**FINAL COMMENTS ON THE  
MODIFICATION OF MAJOR PROJECT  
06\_0063**

**THE PROPOSED REDEVELOPMENT OF CRONULLA MARINA**

**60 Waratah Street, Cronulla**

**Cronulla Marina – Advice to the Director General**

Figure 5 – Location of the Swing Moorings to be Removed

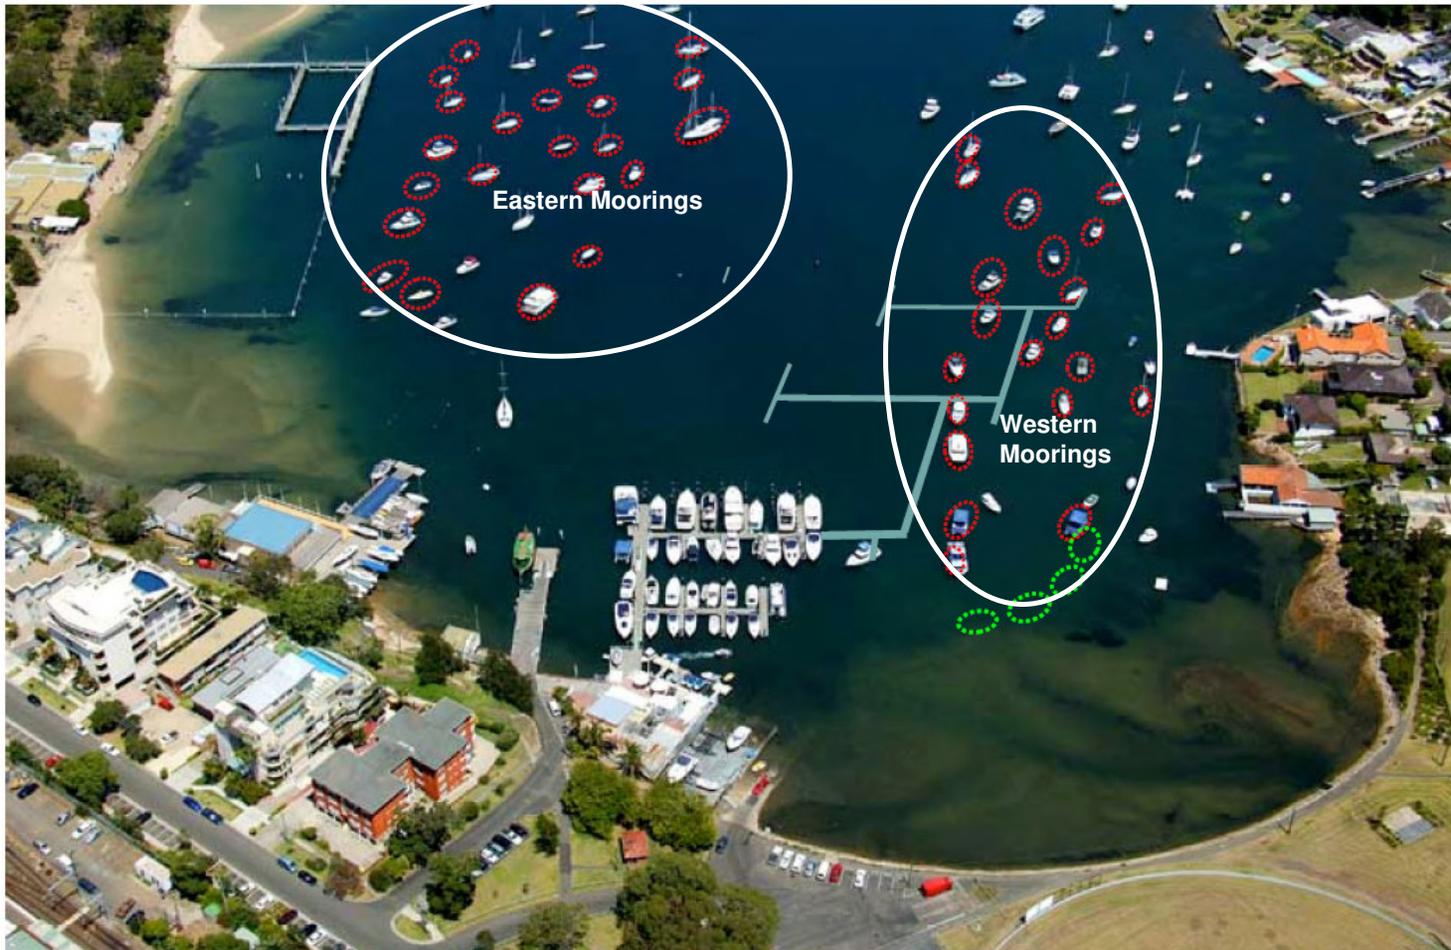
As previously discussed we are of the opinion that the four by fore-&-aft moorings be removed. These moorings limit further growth to the navigation channel for the public boat ramp and may move with further sedimentation of the Bay.

Figure 6 – Proposed Slipway Layout

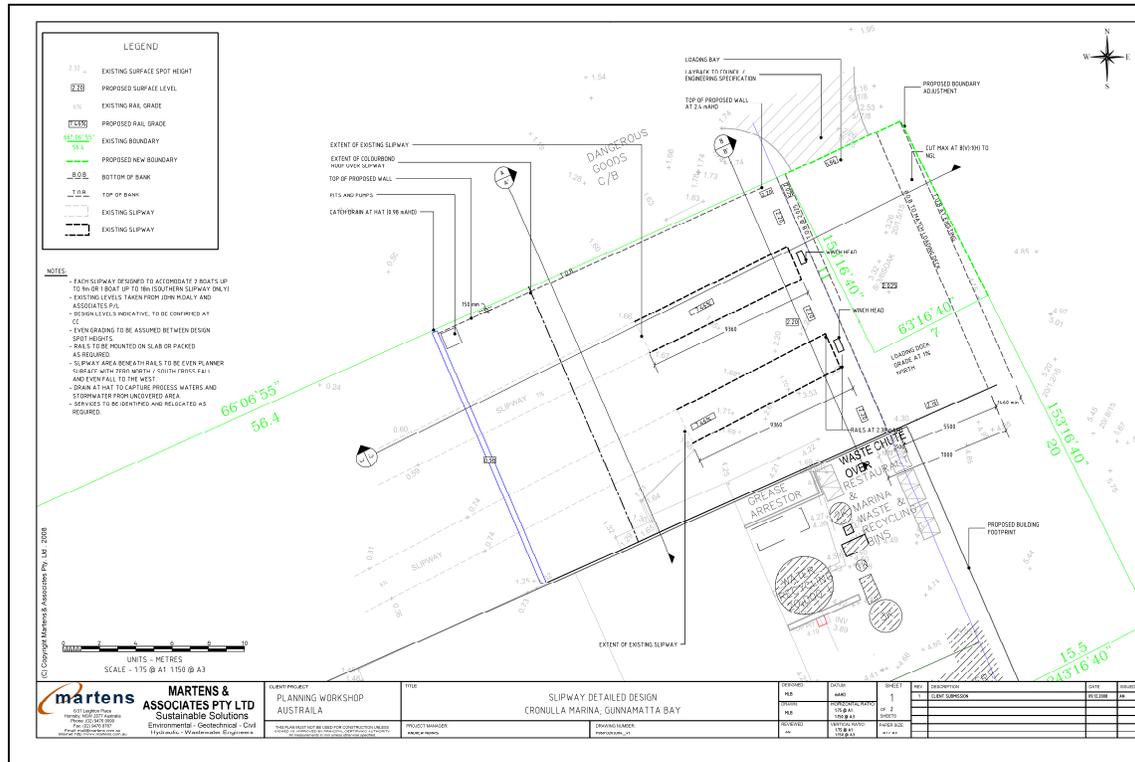
- The EPA is adamant that they will not support any pumping of any water into the Bay. All water collected on the slipway concrete surface including rainwater must go to Sydney Water sewer system.
- The EPA and our office are concerned with the low level of the proposed grated drain collecting all water bound contaminants on site. We note that the slipway redevelopment proposes a grated drain at RL.0.98 (AHD). This figure when related to zero tide is equivalent to a 1.905m. Gunnamatta Bay is expecting tides as high as 2.0m this year excluding storm or wind surges. The following tides are expected this year;
  - i) 1.8m high – 29 tides expected
  - ii) 1.9m high – 16 tides expected
  - iii) 2.0m high – 1 tide expected

- Note that the grated drains need to be located at a level that allows for a design wave at any of these high tides. At a minimum the slipways need a grated drain located at RL.1.525 (AHD) and a second lower grated drain at RL.1.225(AHD). These two figures are equal to a 2.5m tide and a 2.2m tide. In discussions with the EPA they are supportive of the two grated drain system at the above mentioned levels.

Figure 7 – Overlay of the Original (Marked in Red) and Revised Site Area (Marked in Black)

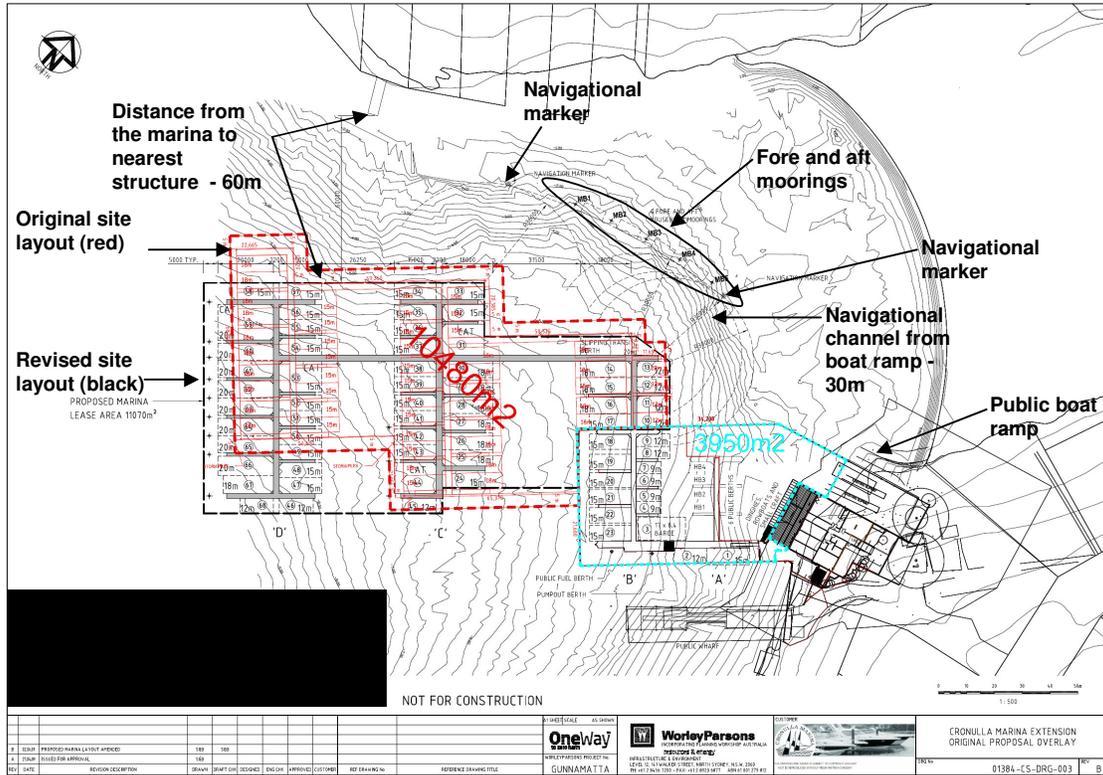
The revised proposal for Major Project 06\_0063 is detailed on drawings numbered 01384-CS-DRG-001 Rev A and 01384-Cs-DRG-002 Rev A. In essence the design has increased in size with an increase in the maximum vessel size. We comment on the physical aspects and controls associated with the modification to the Cronulla Marina Extension Design as follows.

The Marina has grown in size. The increase in marina size is due to two factors, an increase in the maximum vessel to be berthed at the marina and an increase in interior navigation channels above the minimums set by AS3962-2001. A comparison between the revised design and the original design submitted by the proponent shows that;

- The existing marina had an extension of 143m into the Bay (Southwest). This dimension was taken from the north western most extent of the Arm 'B' extension to the southwestern most extent of the mooring pen now designated No.59 and the lease line to it's southern face.
- The new revised and modified proposal, using the same reference point for this extension into the Bay, extends 155.3m southwest into the Bay. The modified design as represented by drawings numbered 01384-CS-DRG-001 Rev A and 01384-Cs-DRG-002 Rev A is 12.3m longer and hence has a 12.3m greater extension into the Bay. However;
- The original marina modification had an east-west width for Arm 'D' set at 78m.
- The proposed modified design sets this width from the eastern most extent of Arm 'D' to the western most extent at 69.7m.

- The footprint of the lease for the proposed modified redevelopment is 14,620m<sup>2</sup>. The footprint of the lease for the original proposed redevelopment of Cronulla Marina is 14,457m<sup>2</sup>. The revised proposal has an increase in proposed plan footprint and lease plan footprint of 163m<sup>2</sup>.

In conclusion the proposed modified Cronulla Marina Redevelopment extends 12.3m further into the Bay (southwest) and extends across the Divisions of Waterways of one additional residence to the immediate west but is 8.3m narrower across Arm 'D'.
